Your Ref: 2020/90119
Our Ref: W000665

17th March 2020

Former Petrol Station, North Road, Kirkburton, Huddersfield - Discharge conditions 12 (Drainage) and 13 (Water Supply Protection) on previous permission 2016/93935 for demolition of existing petrol station and erection of 4 retail and residential units (within a Conservation Area) (modified proposal)

Title: DRAINAGE LAYOUT			
Job No: 2242	DRN: MM	Date: 24/12/2019	
Scale: 1:125 (A1)	CHK: UD	DRG. No.: ESE-DR-S-001: P1

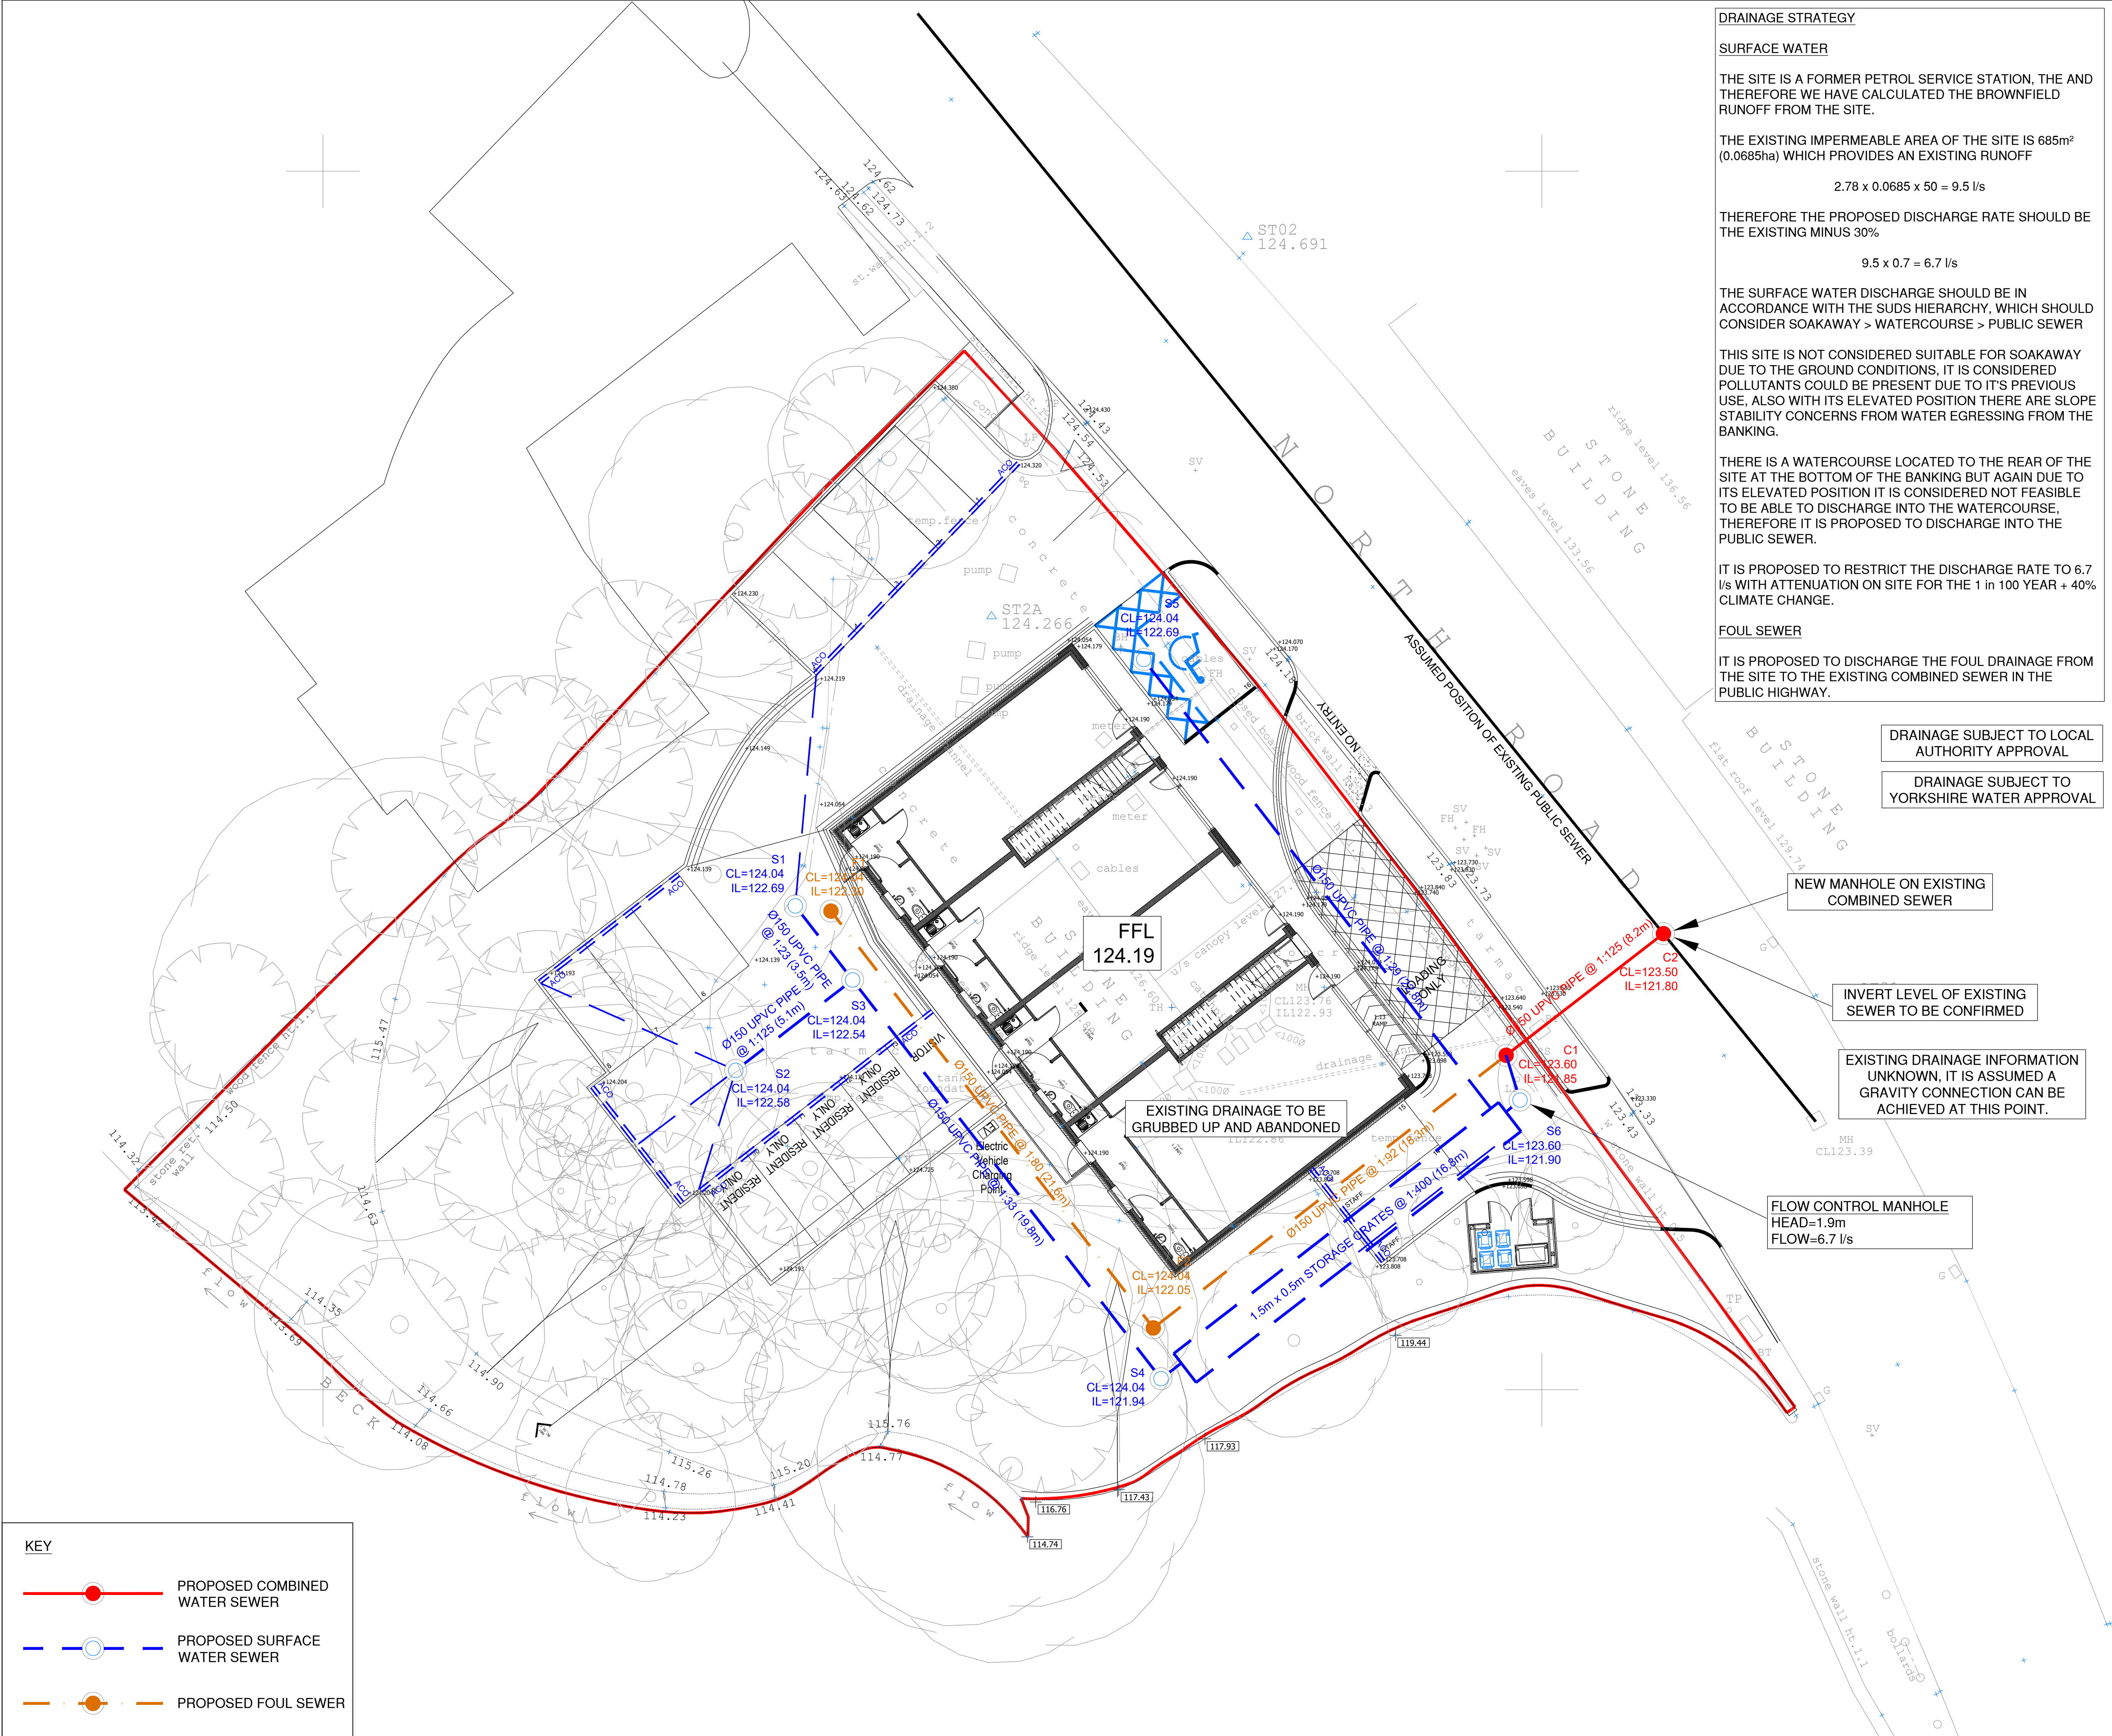
Yorkshire Water still object to the discharge of condition 12.

- 1) From the submitted information, it is indicated that infiltration and discharging to watercourse cannot be utilised as a method of surface water disposal.
- 2) To decide on whether a discharge to the public combined sewer can be accepted, a full existing topographical survey is required. If positive connectivity from the existing site to the public sewer network can be proved highlighting all the existing impermeable areas draining to it, we can agree a rate based on this.

If no survey can be submitted, we will accept a maximum discharge rate of 3.5 (three point five) litres per second.
